**SUBMISSION TO THE DEPARTMENT OF PLANNING AND INFRASTRUCTURE ON THE PROPOSED
NORTH WEST RAIL LINK (NWRL)**

Name: ALLAN PIERCY

Application Number: SSI-5100

Whilst I support in principle the construction of the NWRL to provide much needed public transport to the rapidly growing housing areas of north west Sydney and to reduce the pollution and congestion associated with road transport, I object to the following regarding the Cheltenham Intermediate Services Facility.

Figure 6.11 Cheltenham Services Facility light vehicle access and egress

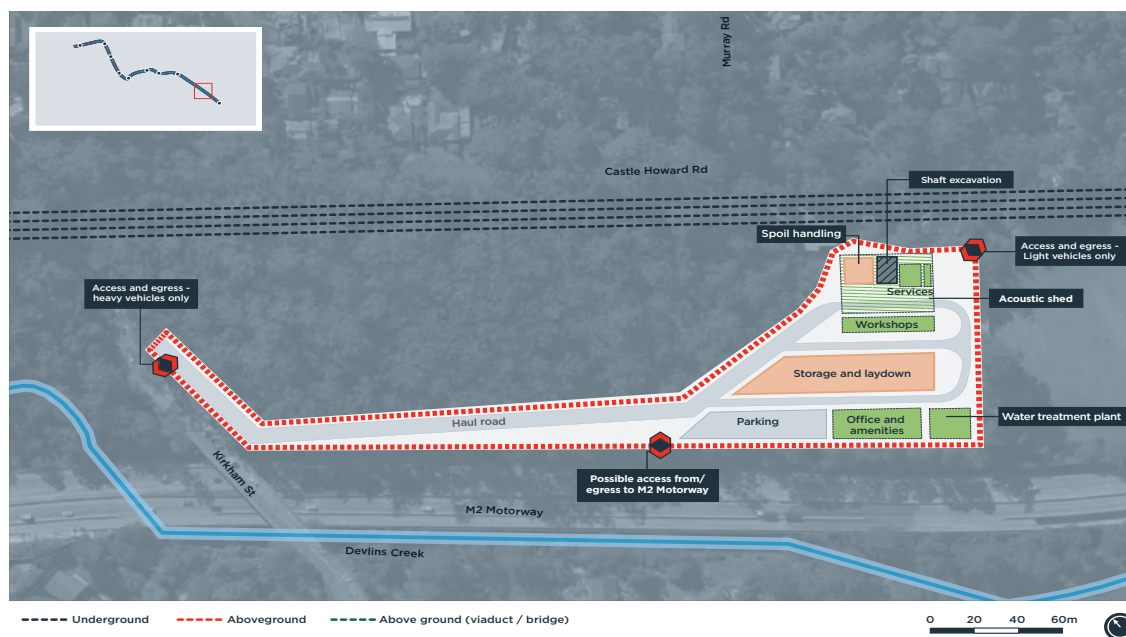
1. The option to construct a new two lane paved road through the Castle Howard Conservation Reserve to Kirkham Street (or Castle Howard Road) near the bridge over the M2 to allow trucks to remove spoil during construction and light vehicle access during operation of the facility will permanently destroy valuable Blackbutt Gully forest.

5. Should the roadway be built, the local streets (Kirkham Street, Castle Howard Road, Murray Farm Road and the bridge over the M2) are narrow, winding and congested and would not be suitable for trucks and, in the event of an emergency, large numbers of emergency vehicles.

6. There are no traffic lights at the corner of Kirkham Street and Beecroft Road. This is a dangerous intersection for traffic and pedestrians and would not be suitable for trucks and emergency vehicles.

I therefore ask that you adopt the alternative option of access to the site for construction and emergency vehicles be via new on and off ramps from the M2 motorway. The current widening and reinstatement of the breakdown lane should allow this access. It is the only practical way to move trucks in and out of the site. In the event of an emergency, many emergency vehicles would need quick access to the site from areas outside Beecroft and Cheltenham as it only has one fire engine.
